Recommendation Report for Planning Permission for Works or Extension to a Dwelling

REF NO: M/137/21/HH

LOCATION: 3 North Avenue
Ancton
Middleton-On-Sea
PO22 6HF

PROPOSAL: First floor roof extension.

First Floor

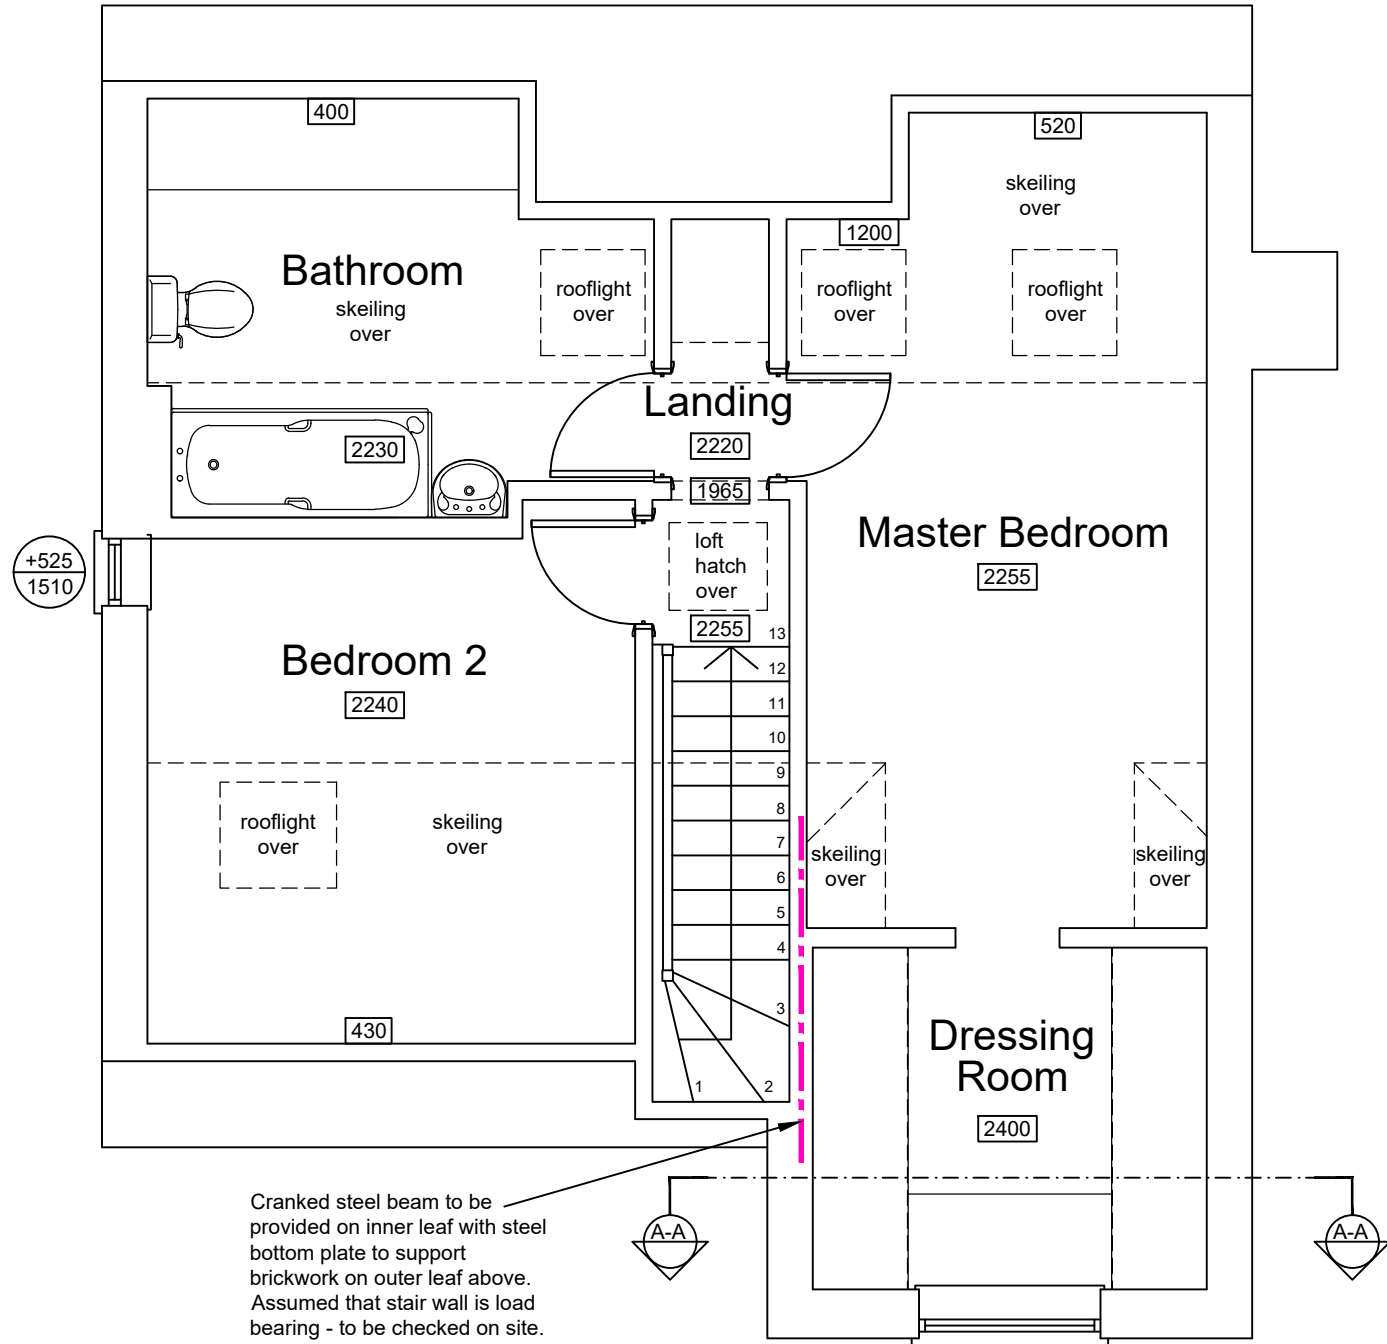
The extension will not breach the 45 degree rule from the neighbouring property no. 5 North Avenue which will ensure there is no adverse overbearing impact or overshadowing. The Council uses the 45 degree rule as a rule of thumb drawing a line from the nearest window at 45 degrees and ensuring that new development does not encroach upon this line.

Proposed Elevations

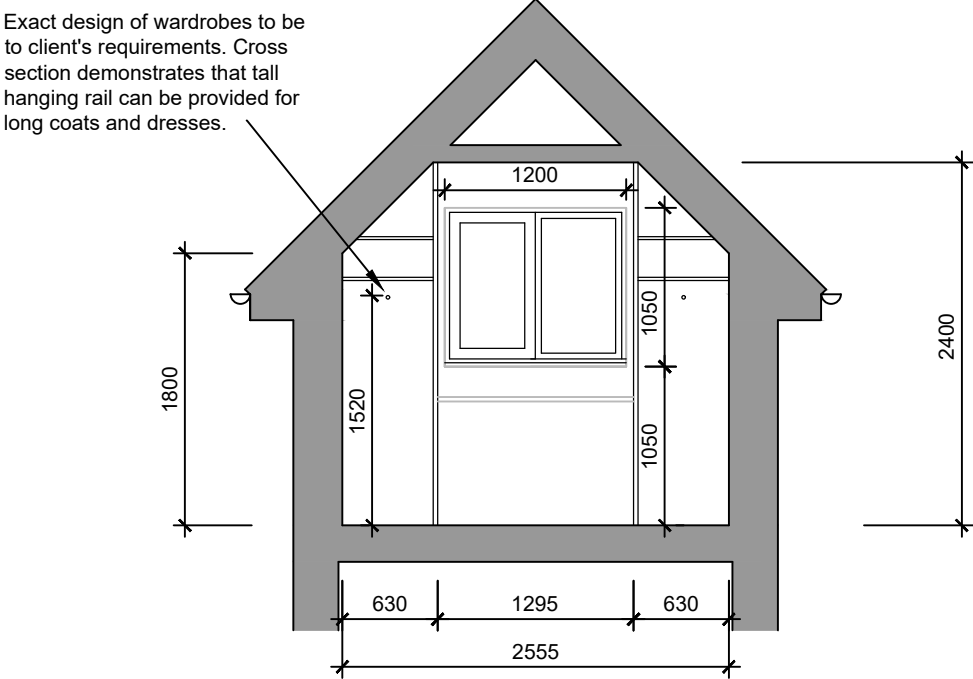
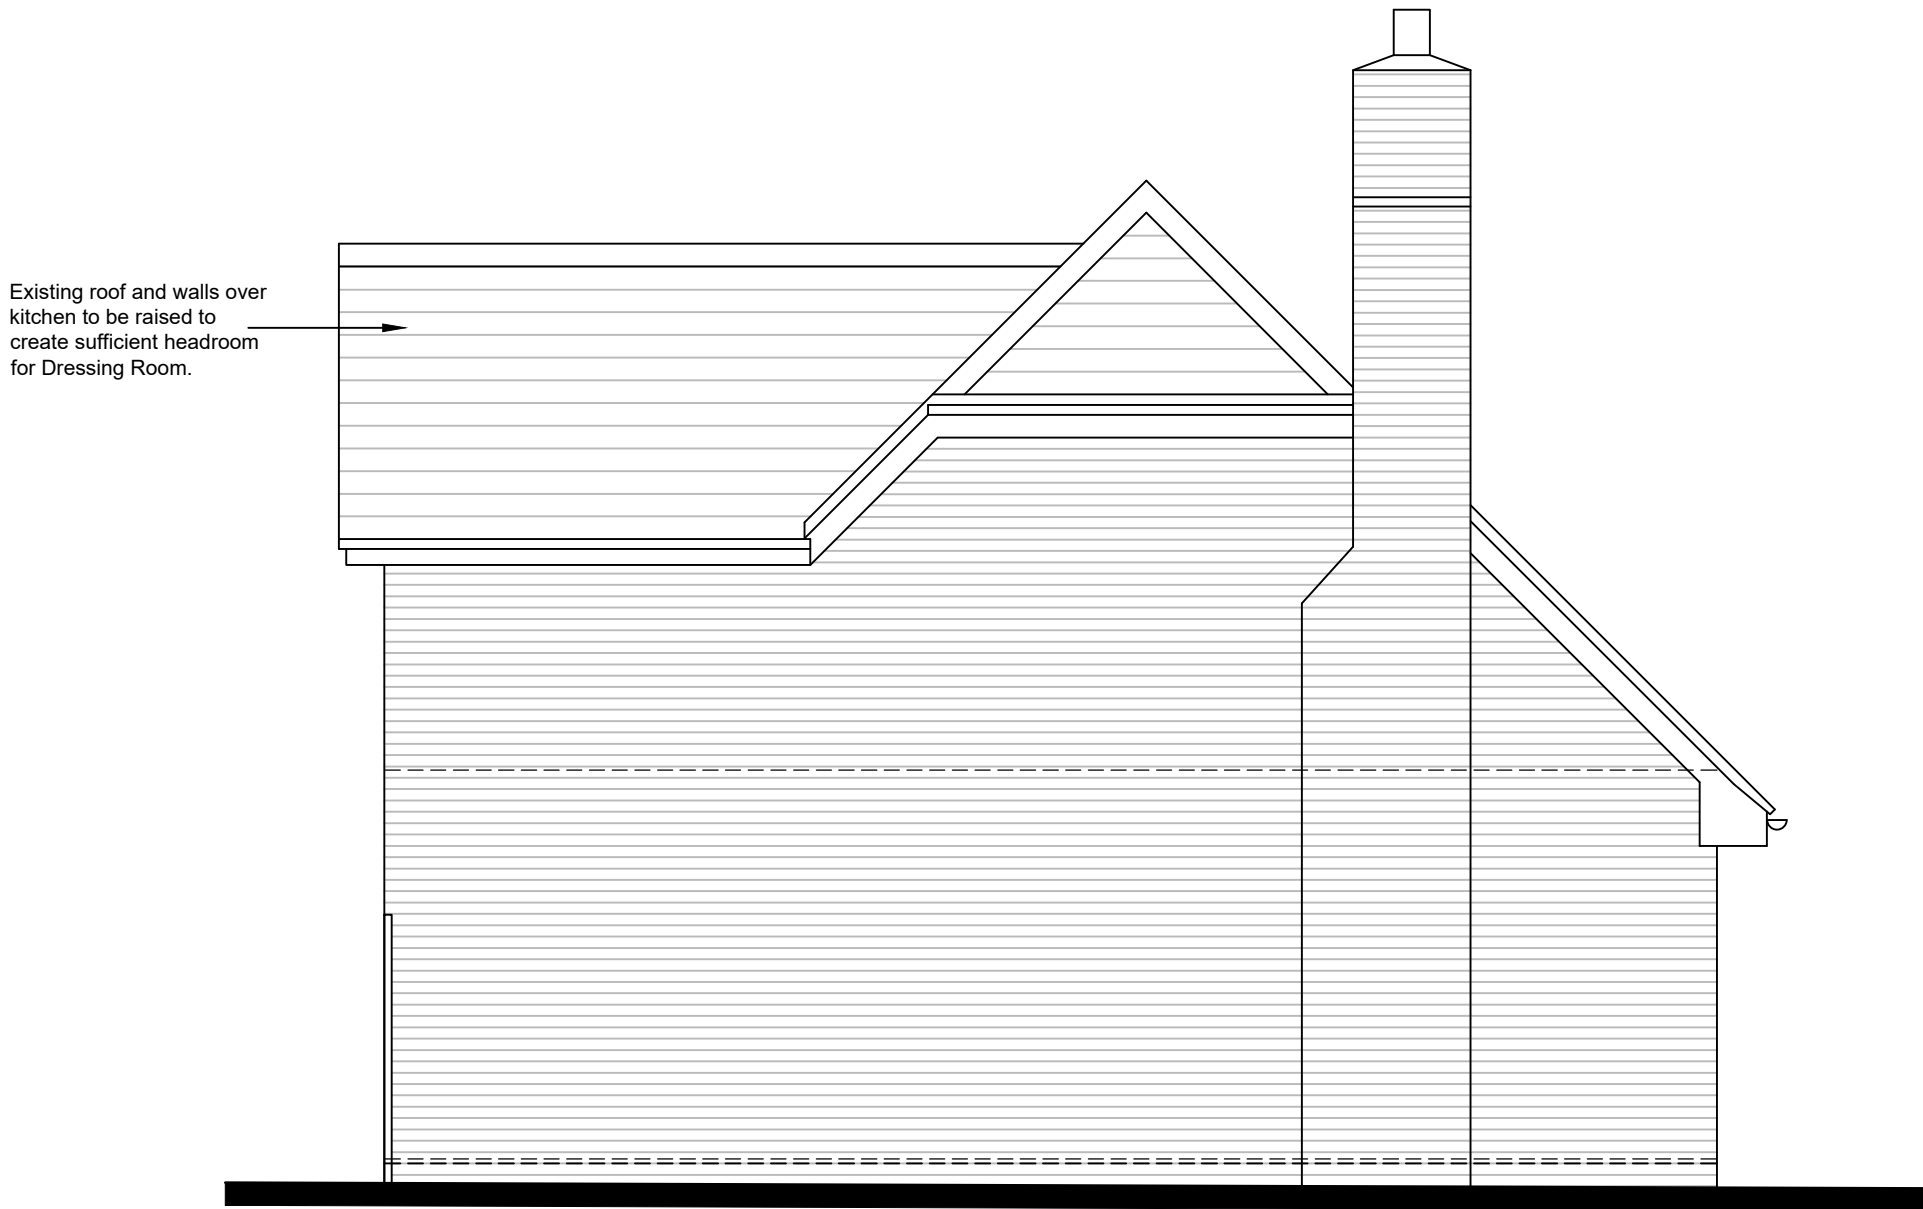
The extension is a roof extension continuing the front outrigger upwards to form a new room and will not harmfully disrupt the existing relationship with neighbouring building lines.

The roof would be pitched, although set around 0.8m below the main ridge at a right angle to the main roof. It is considered that the siting, scale and design of the proposed extension is such it would be in a subservient and well integrated addition.

Section M of the Design Guide states 'Extensions should respond to and complement the existing character and appearance of the building and wider townscape in terms of scale, massing, materials, openings and roof form.' The proposal complies with the design guide being of appropriate scale to the host dwelling.

The extension will be glazed to the front elevation although due to its siting and with its first floor position alongside other existing first floor windows in the building is not considered to result in adverse overlooking of 7 and 9 North Avenue
